**RE: McDonald's – 5001 Gibson SE
Grading and Drainage Plan
Stamp Date: No Stamp Date
Hydrology File: L18D053**

Based upon the information provided in your submittal received 11/29/2017, the Grading and Drainage Plan **is not** approved for Building Permit. The following comments need to be addressed for approval of the above referenced project:

GRADING PLAN

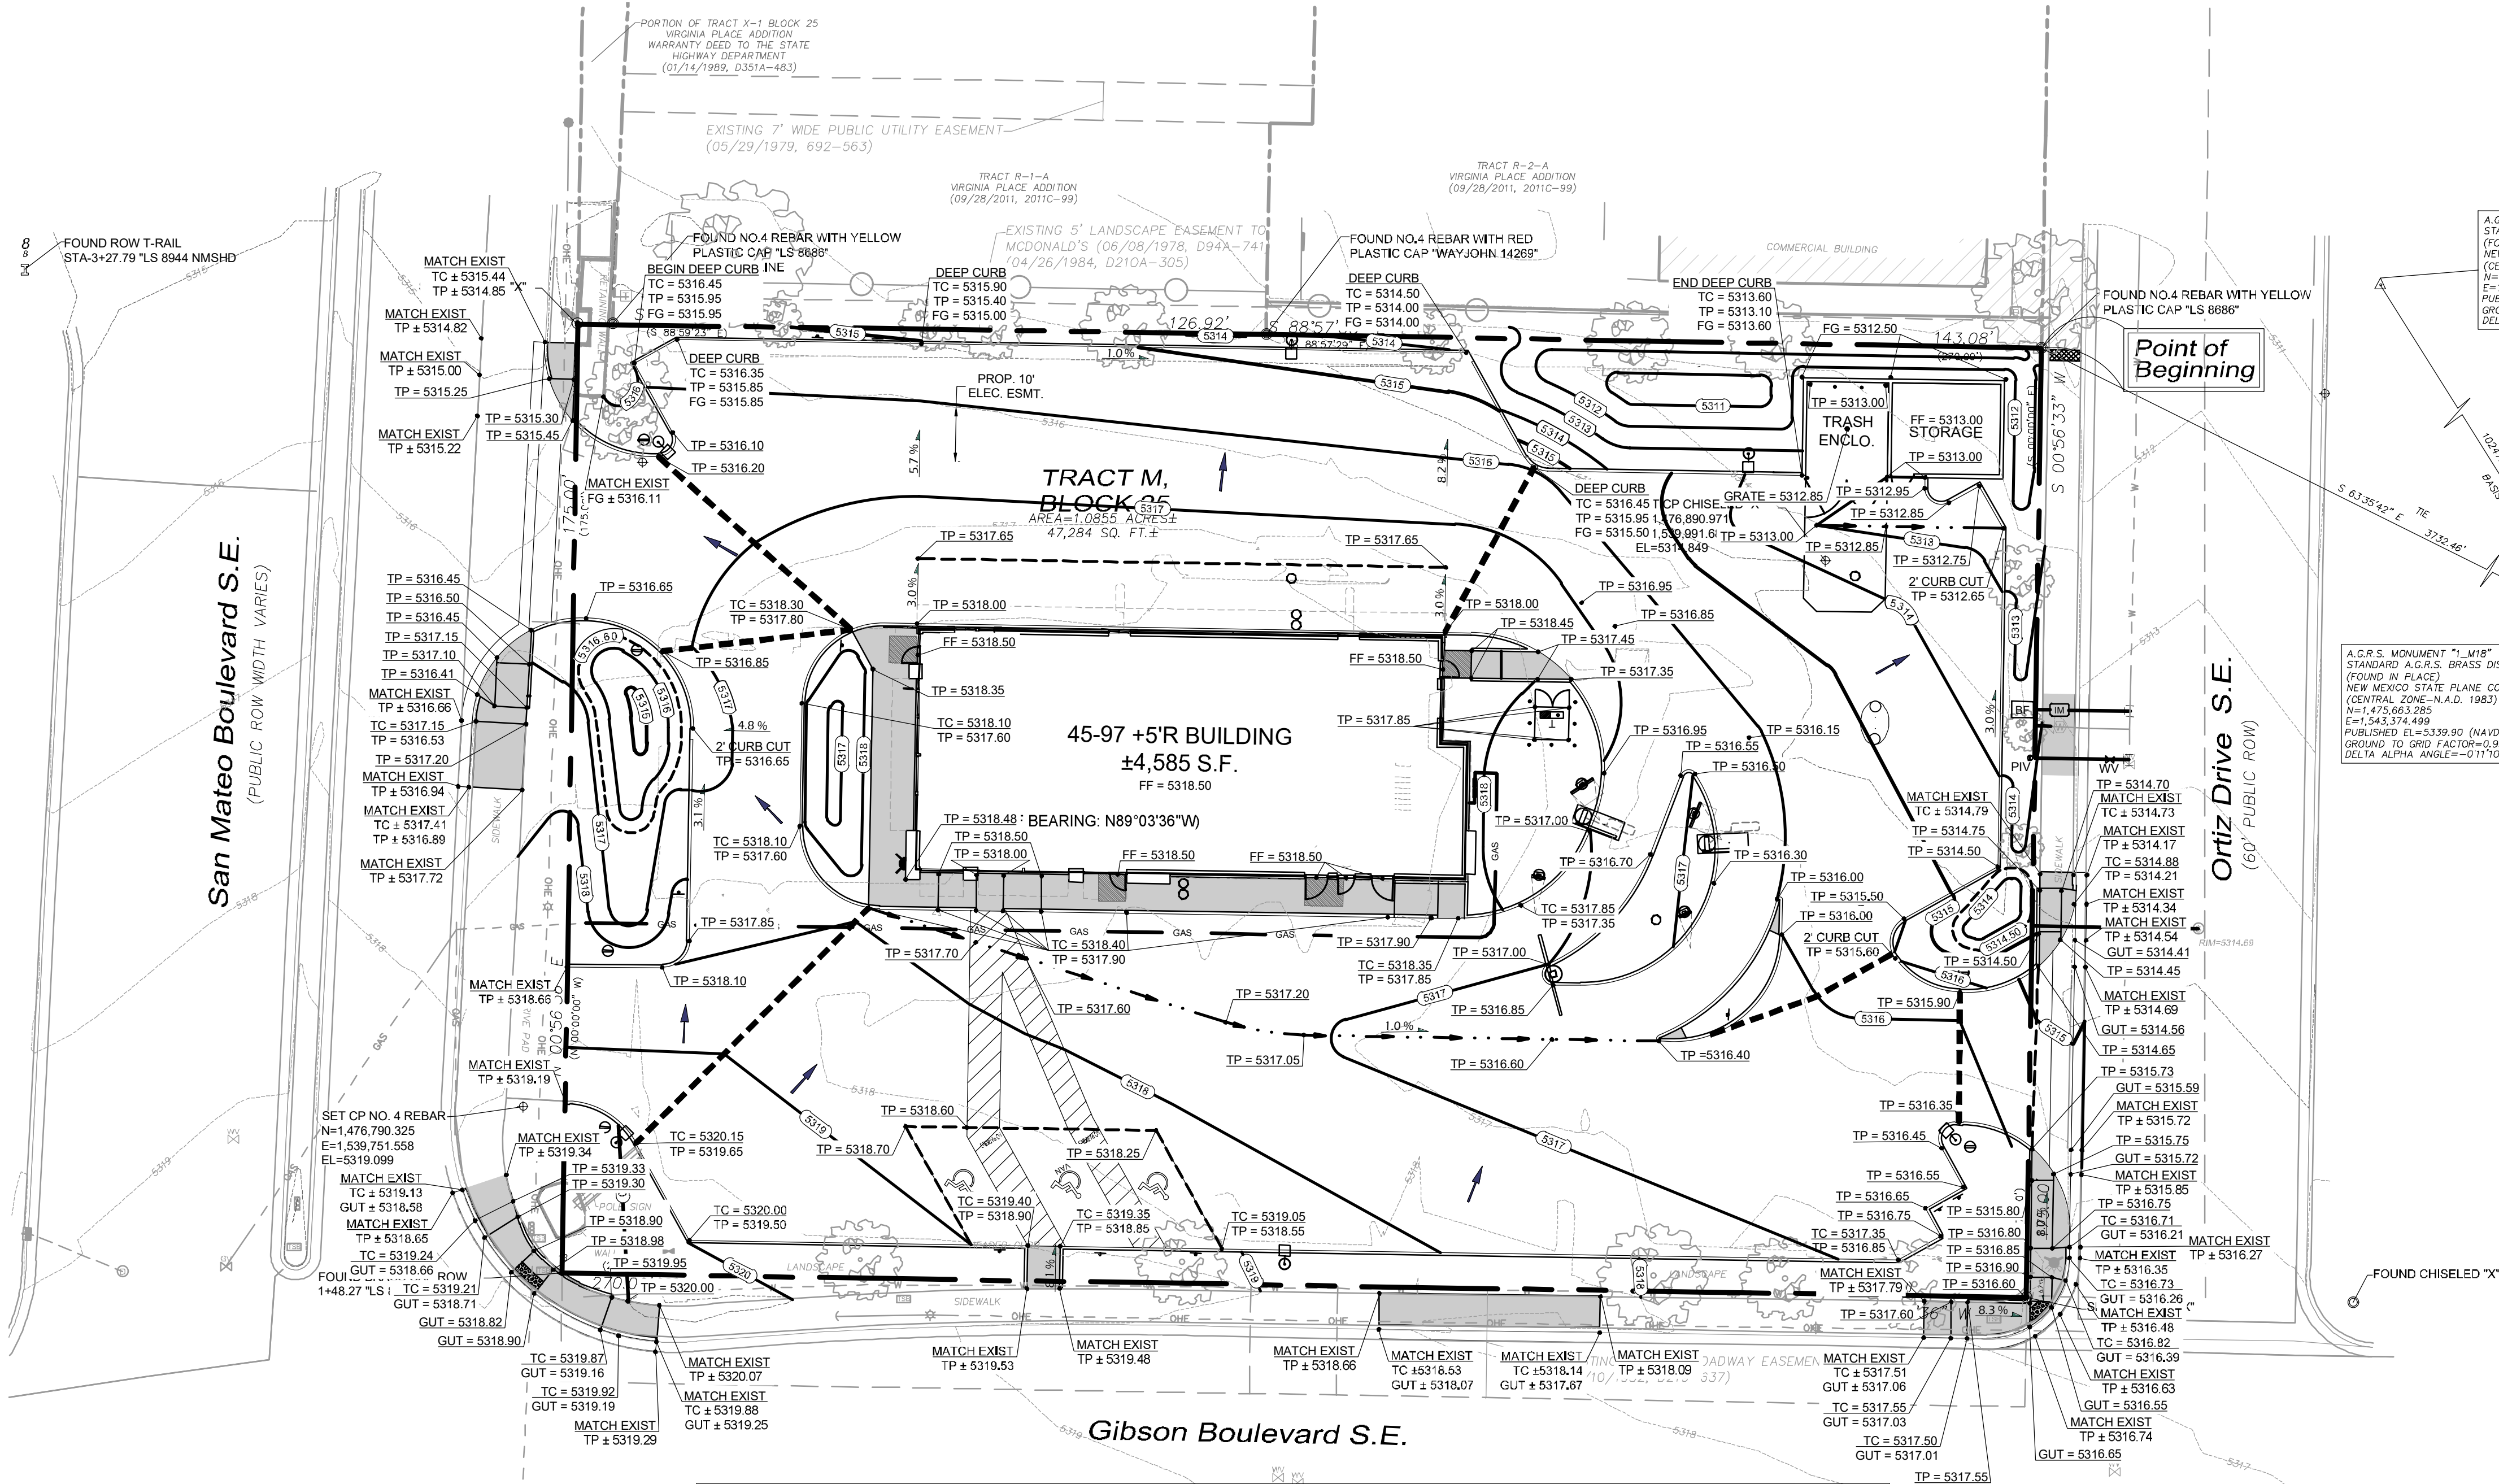
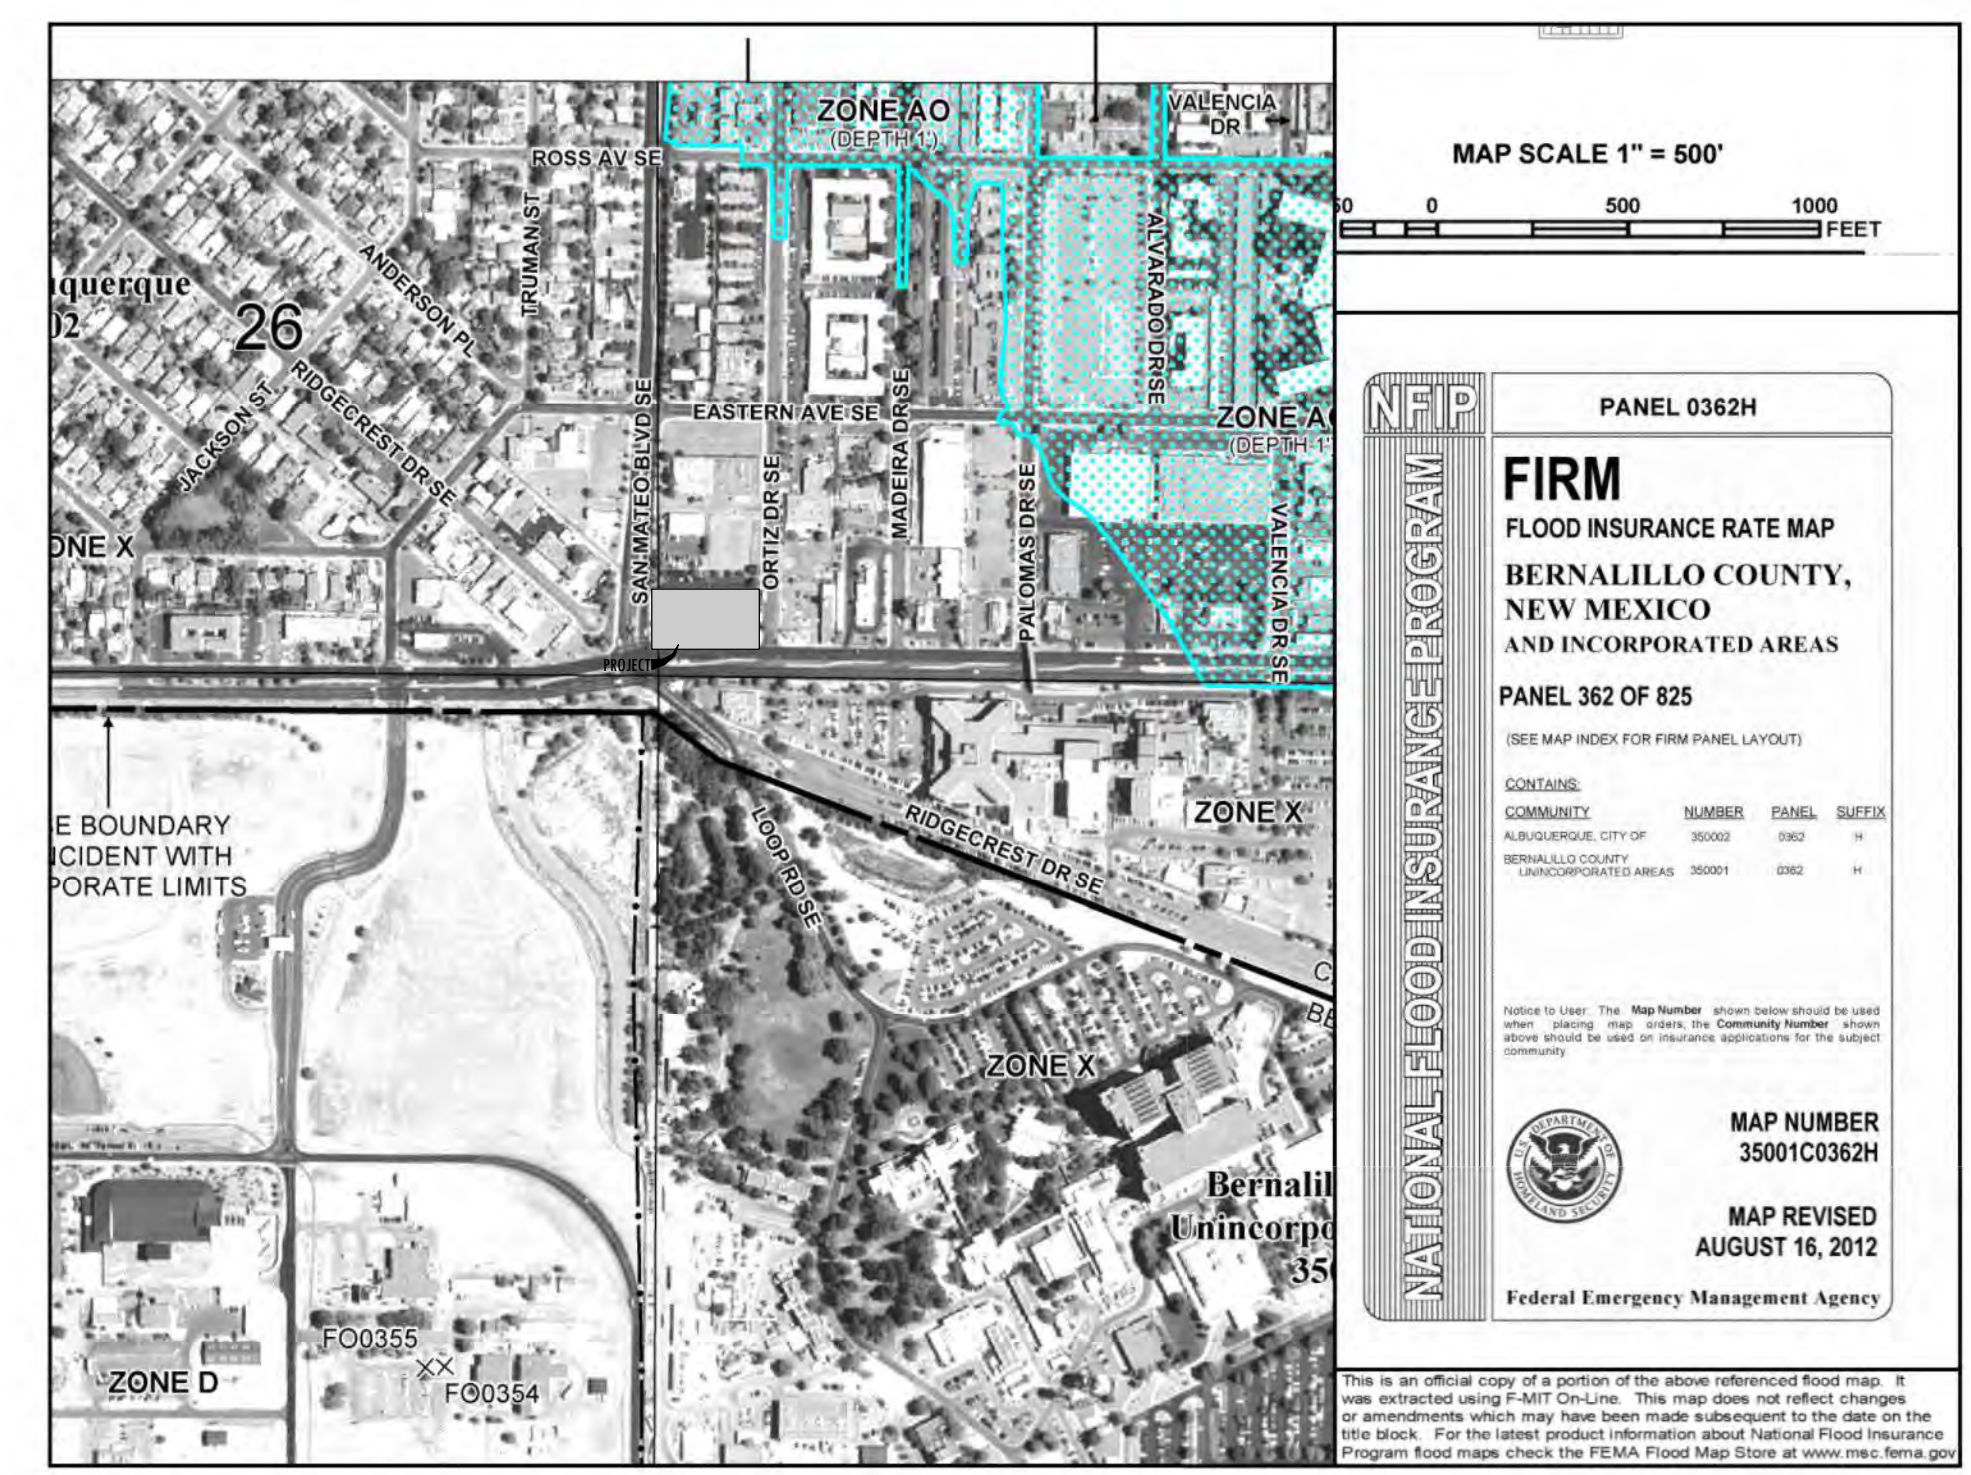
6. Please provide a paragraph stating the Existing Conditions and one stating the Proposed Conditions.
7. Please provide the first flush calculations and show each pond volume on the plan at each pond. All new development projects shall manage the runoff from precipitation which occurs during the 90th Percentile Storm Events, referred to as the "first flush." The Site Plan/Drainage Plan must indicate all areas and mechanisms intended to capture the first flush. For volume calculations, the 90th Percentile storm event is 0.44 inches. For Land Treatment D the initial abstraction is 0.1", therefore the first flush volume should be based on $0.44'' - 0.1'' = 0.34''$ and only consider the impervious areas.

8. Please provide wier calculations (Chapter 22 of the DPM) for the two foot curb cuts.
9. Please provide a curb cut at the north side of the property where there is a first flush pond. The runoff needs to get to the pond.

10. Please show how the drainage is going from the proposed first flush ponds to the street curbs. Please note that runoff cannot travel over the sidewalk or ADA ramps. Please use sidewalk culverts. Then please reference City of Albuquerque standard detail No. 2236 – Sidewalk Culvert with Steel Plate Top at the sidewalk culverts.
